From: Timera Drake <timera@thompsondelay.com>
Sent: Monday, August 22, 2016 4:23 PM
To: Scott Greenberg
Cc: danielphompson@hotmail.com
Subject: Comments on ZTR16-002 and SEP16-015
Attachments: 20160822162540.pdf

Re: File No. ZTR16-002
SEP16-015
Zoning Code Text Amendment and
SEPA Environmental Threshold Determination for MICA

Mercer Island Center for the Arts Seattle, WA	
Limit Equilibrium Slope Stability Analysis Results: Static, Effective Stress Strength	
19120-01	06/18/17
	Figure
3

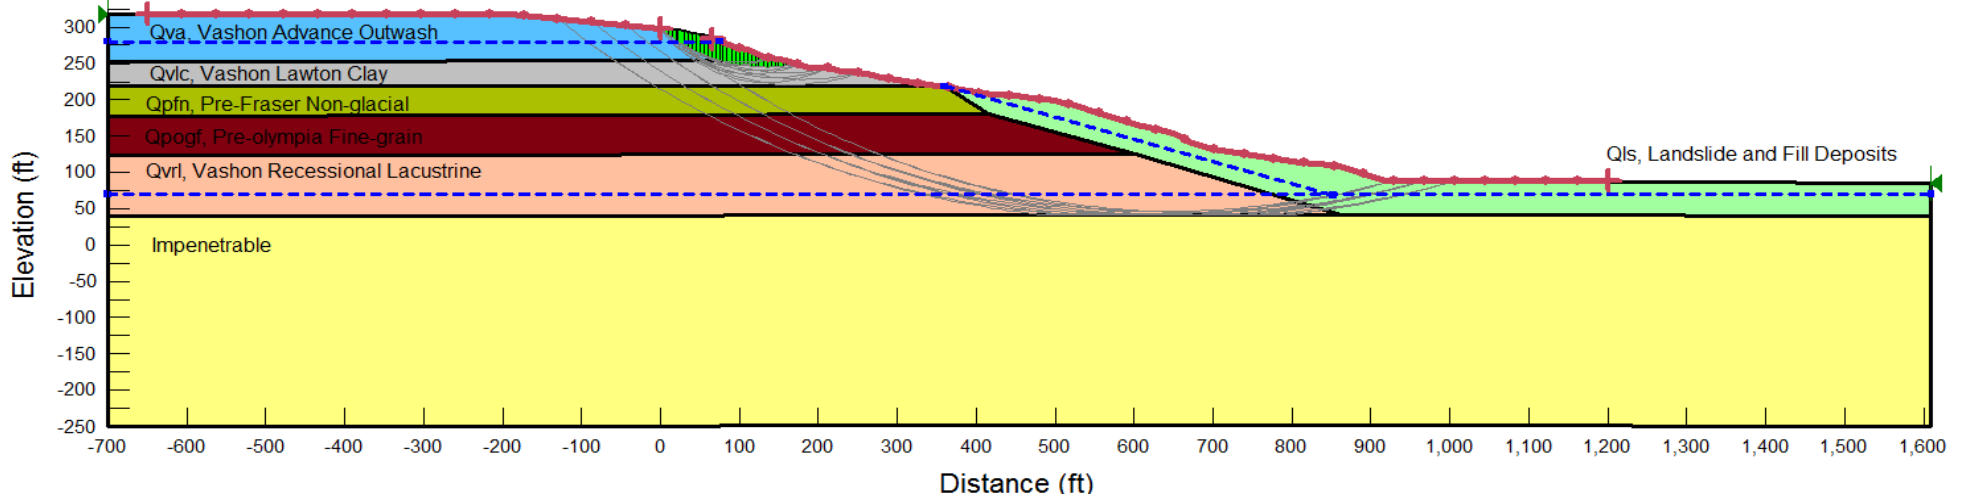
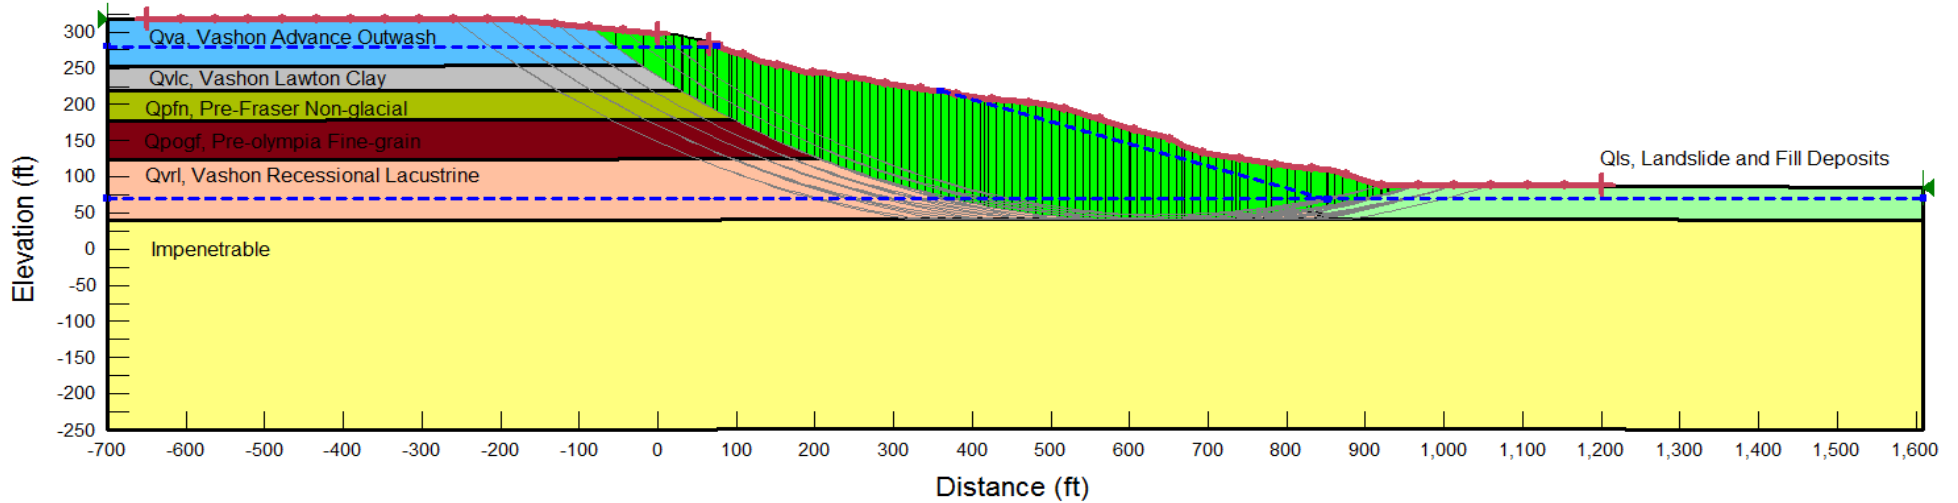
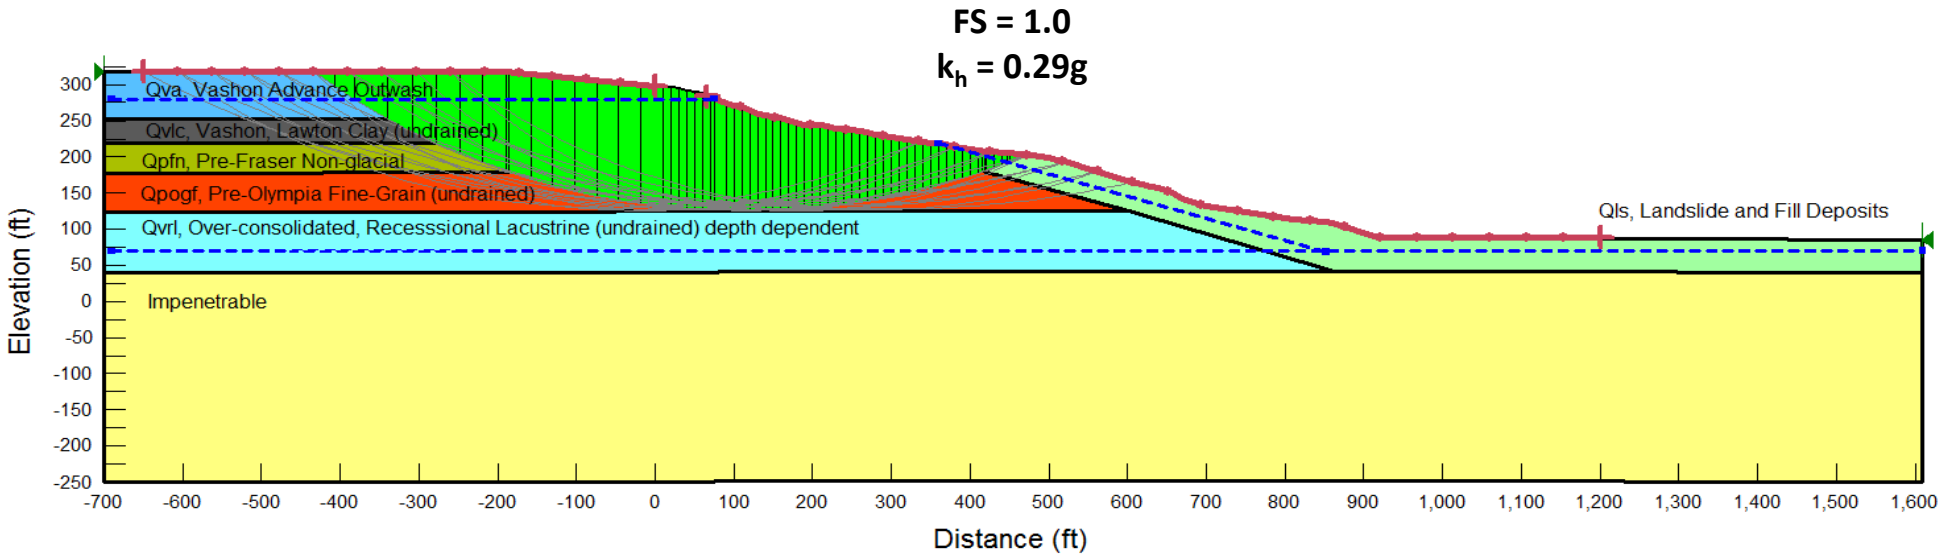
The geotechnical report is flawed in that it addresses the likelihood of a slide from the hillside behind MICA. Although MICA itself is on flat land, it is backed by a steep, heavily-wooded ravine with significant water runoff. The geotechnical report should address the risk to patrons of MICA should a slide occur.

MERCER ISLAND CENTER FOR THE ARTS CONCEPTUAL MITIGATION PLAN

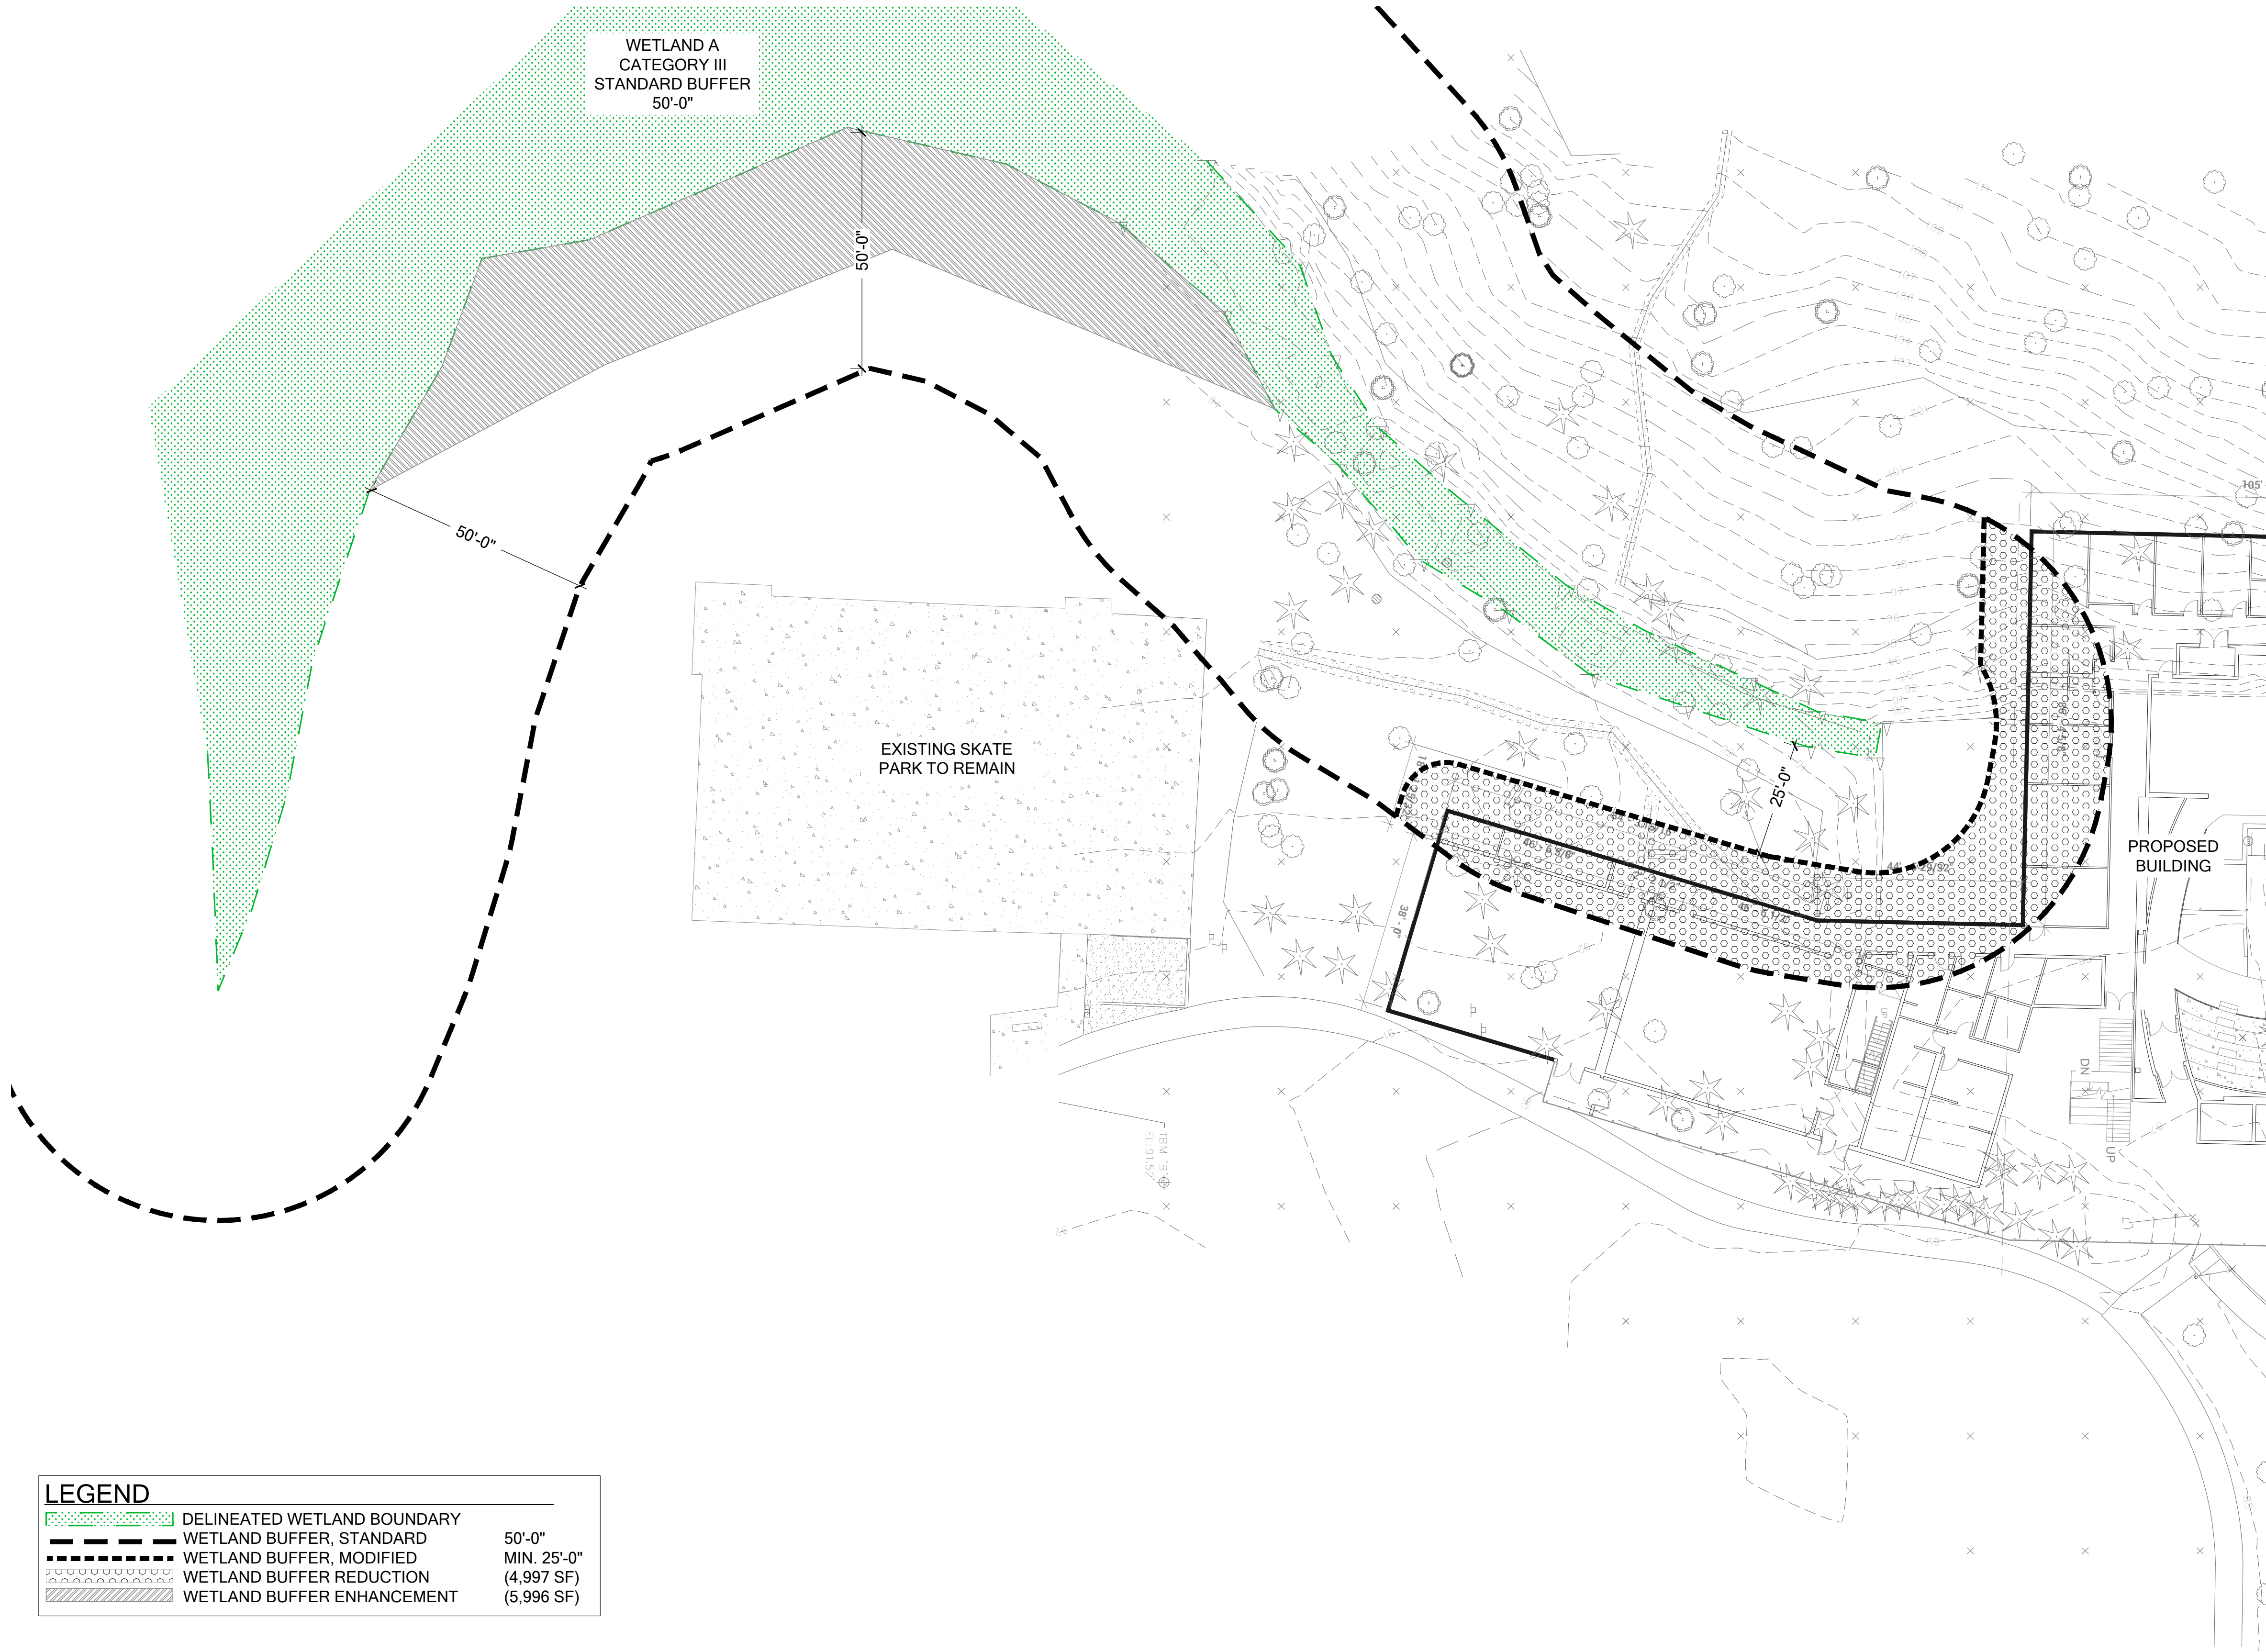
I object to and disagree with MICA's mitigation plan for the loss of wetlands and the effect it will have on flora and fauna.
